**CITY OF PORTLAND, MAINE  
SITE PLAN REVIEW (ADDENDUM)  
CONDITIONS OF APPROVAL**

APPLICANT: Tim Hiltz / Patty Lago  
 ADDRESS: 7 Bramhall Terrace Portland, ME 04103  
 SITE ADDRESS/LOCATION: Auburn Pines Lot #2  
 DATE: 9/26/00

TO: Inspections  
FROM: Jay Reynolds, Development Review Coordinator   
DATE: April 18, 2001  
RE: C.O. inspection for # 23 Garsoe Drive (CBL 386-AA-002)

PLOT PLAN

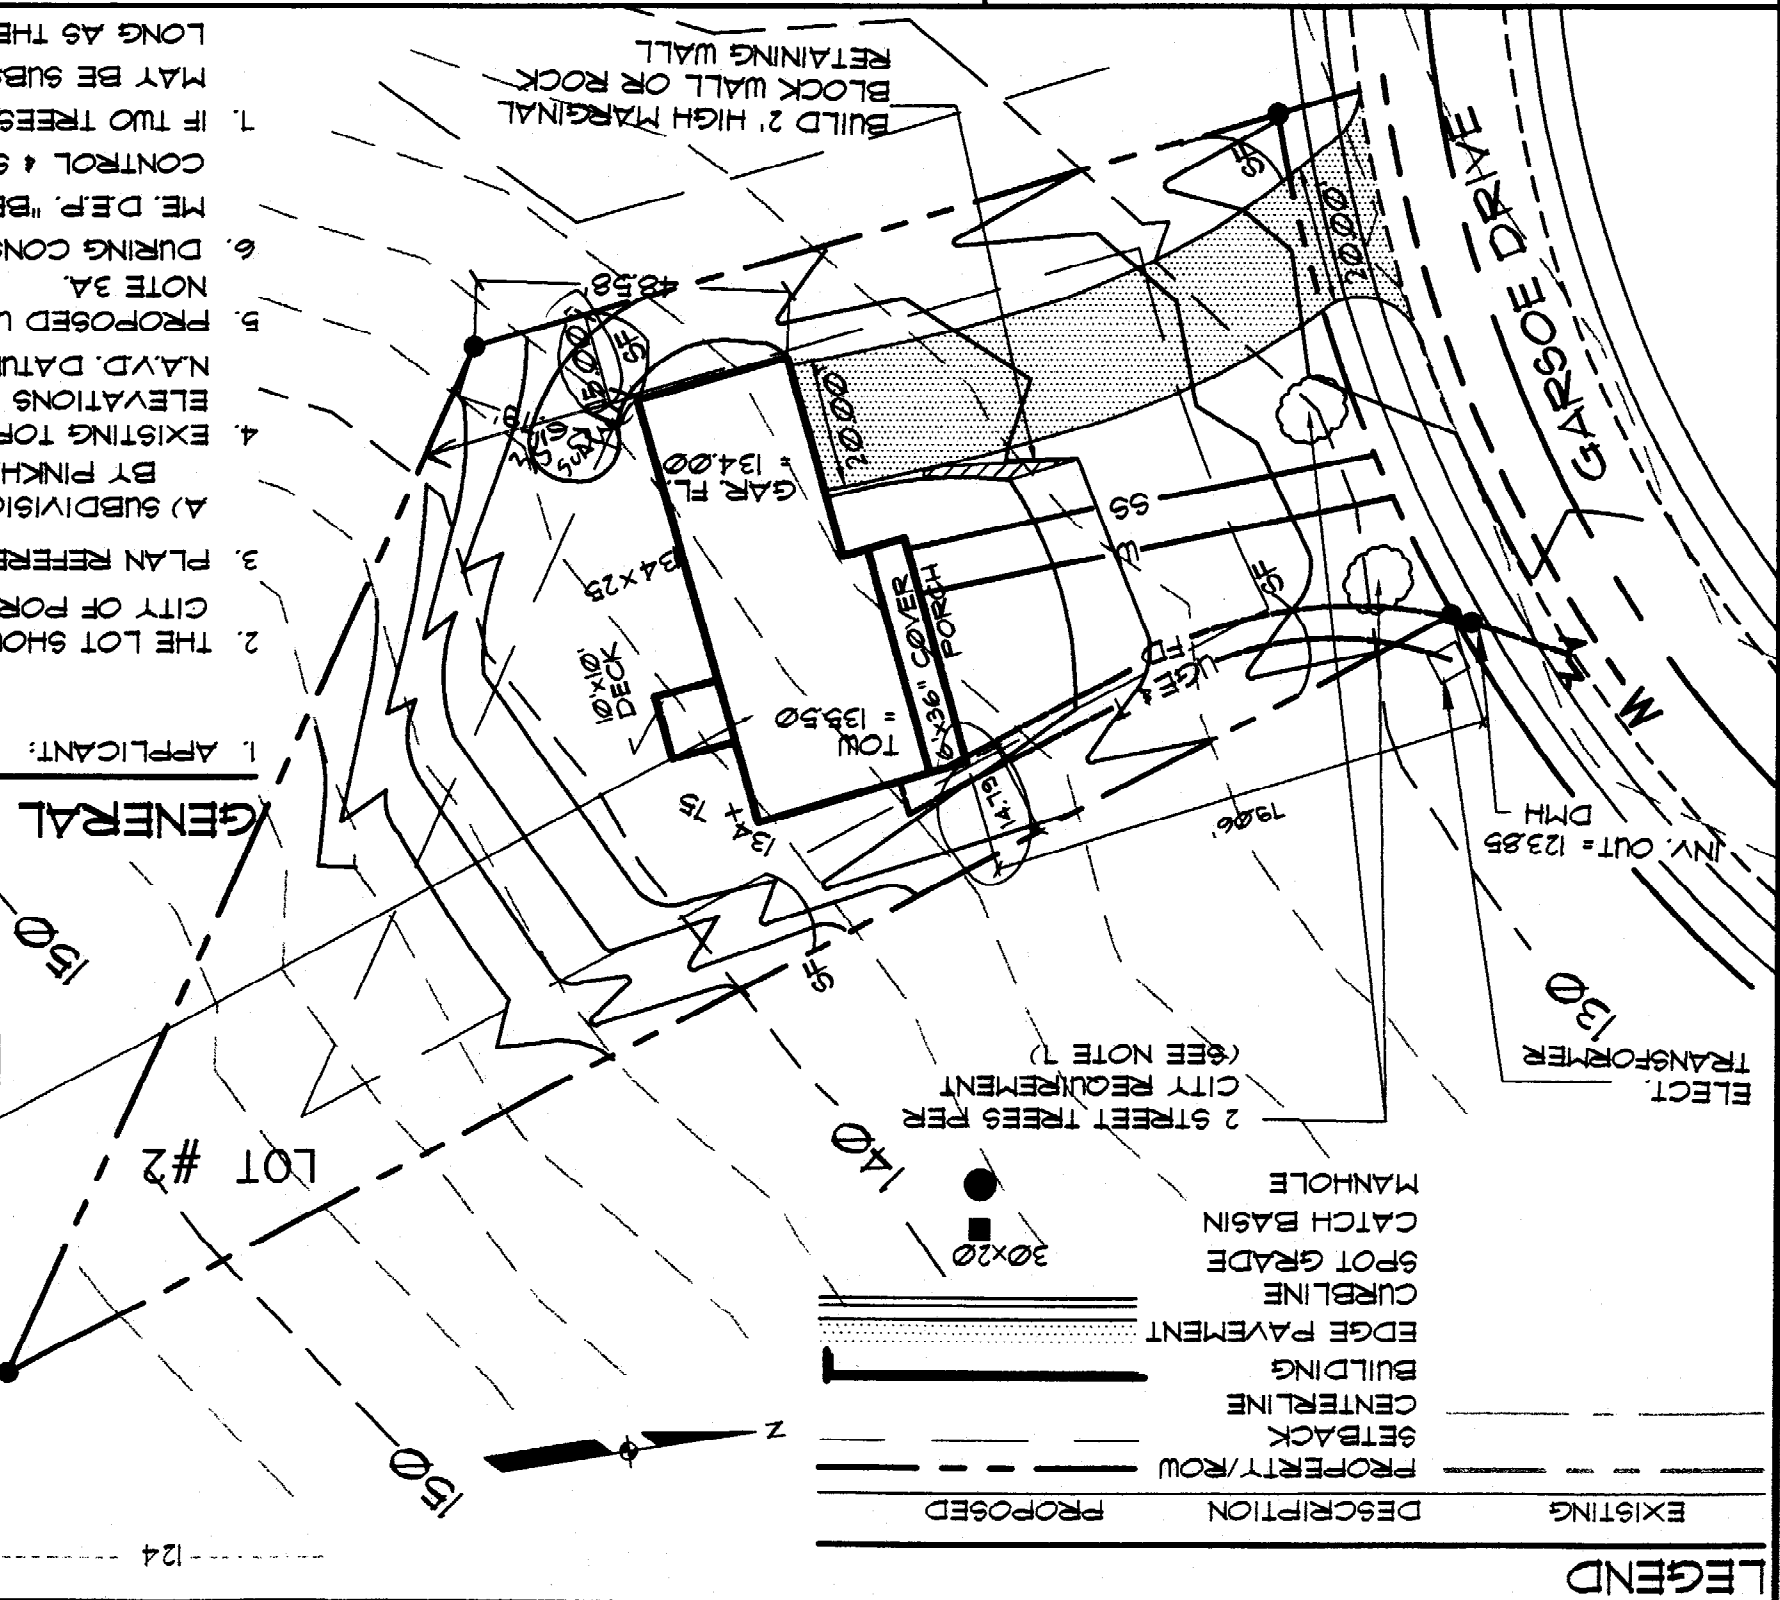
1. The 2 trees have not been installed.
2. Final grading, loam and seed, incomplete.

Due to the time of year and weather conditions, it is not possible to complete these items. I would estimate that these items could be completed by June 30, 2001. Once these items are addressed and re-inspected, then a permanent Certificate of Occupancy can be issued.
